**Rezoning Transportation Analysis**  
**Petition Number: Insert Zoning Petition #2021-219**  
*General Location Identifier: 12521103*

**Revision Log:**

Date	Description
01/21/2022	First Review (WB)
02/21/2022	Second Review (WB)

RZ-1.0

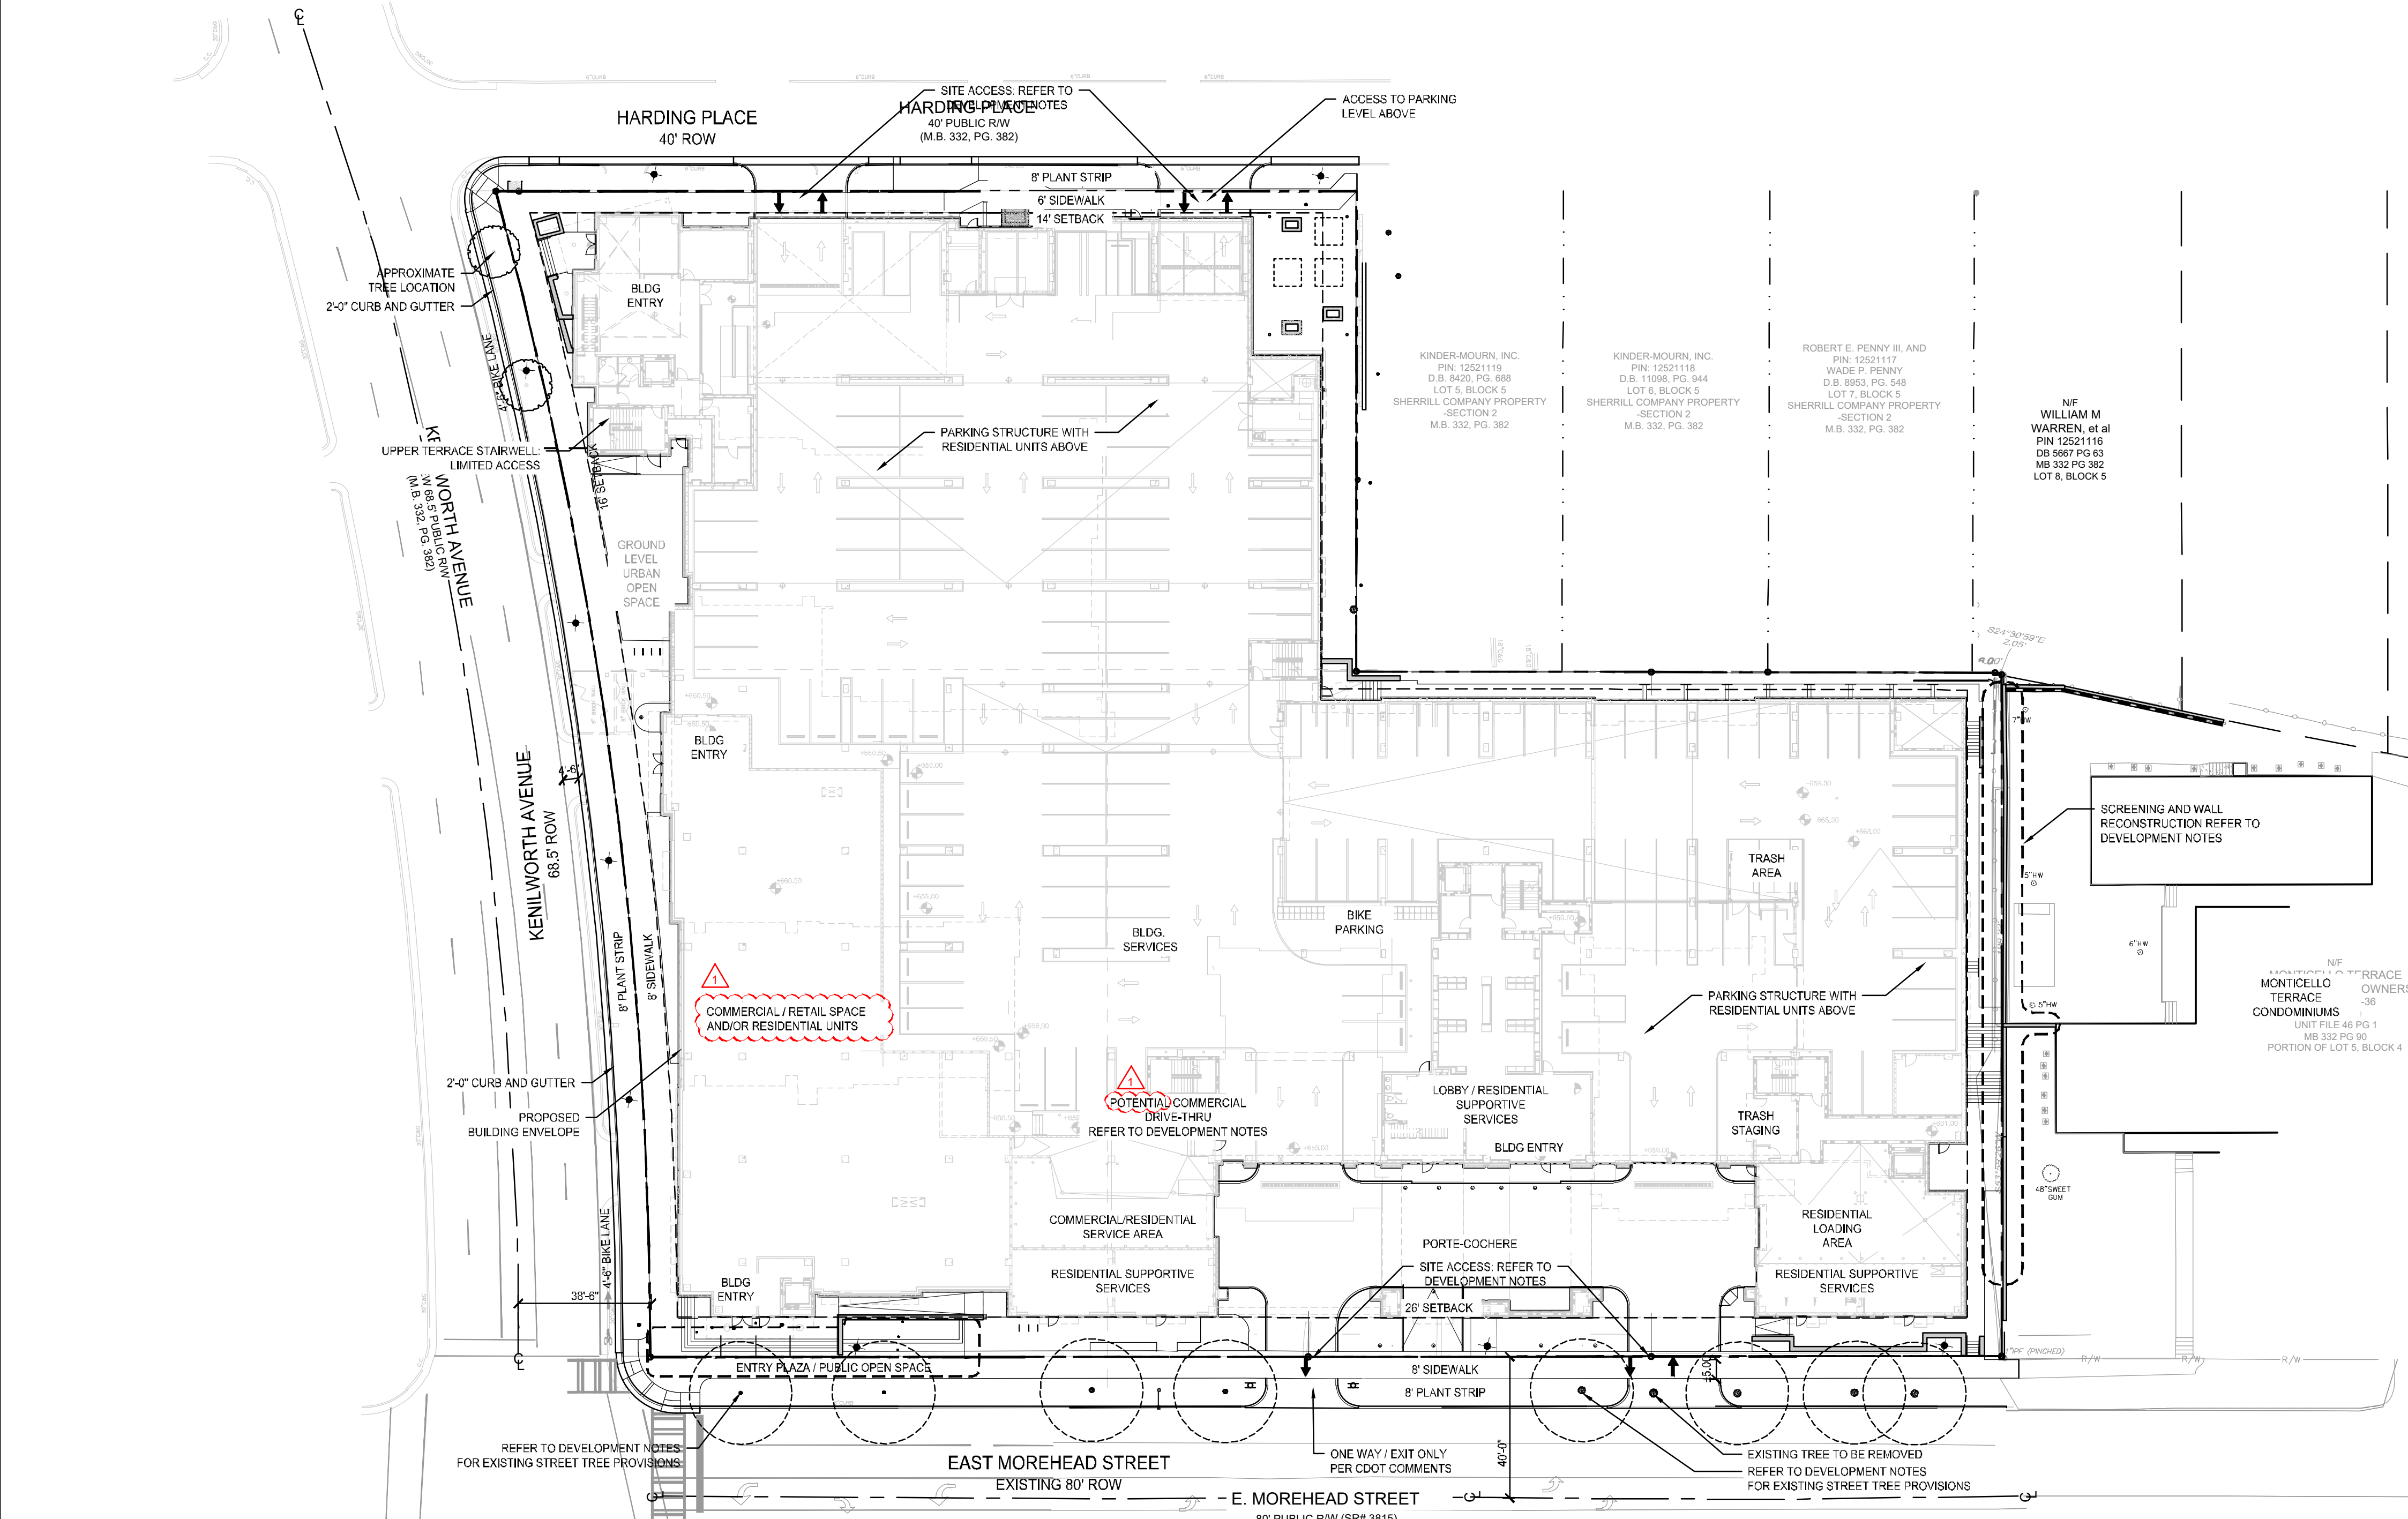
1. ~~**Curblines:** The proposed zoning district has a setback measured from back of the existing or proposed future curblines.~~
  - a. ~~**Morehead Street:** The future location of curb and gutter measures at 36 feet from the centerline to the back of curb to accommodate buffered bike lanes; however, no curb relocation is being required with this petition and the existing curb and gutter may remain at its current location.~~
  - b. ~~**Kenilworth Avenue:** The existing curb and gutter is in its future location.~~
  - c. ~~**Harding Place:** The existing curb and gutter is in its future location.~~

~~Label and dimension the curb and gutter from the centerline for each road on the site plan.~~

3. Add a site plan note specifying that all transportation improvements will be approved and constructed before the site's first building certificate of occupancy is issued as needed. The petitioner may phase transportation improvements if said improvements and phasing are explicitly described in site plan notes.
4. Add conditional note "All public roadway improvements will be subject to the standards and criteria of CDOT and NCDOT, as applicable, to the roadway improvements within their respective road system authority. It is understood that such improvements may be undertaken by the Petitioner on its own or in conjunction with other development or roadway projects taking place within the broad Central Mecklenburg area, by way of a private/public partnership effort or other public sector project support."
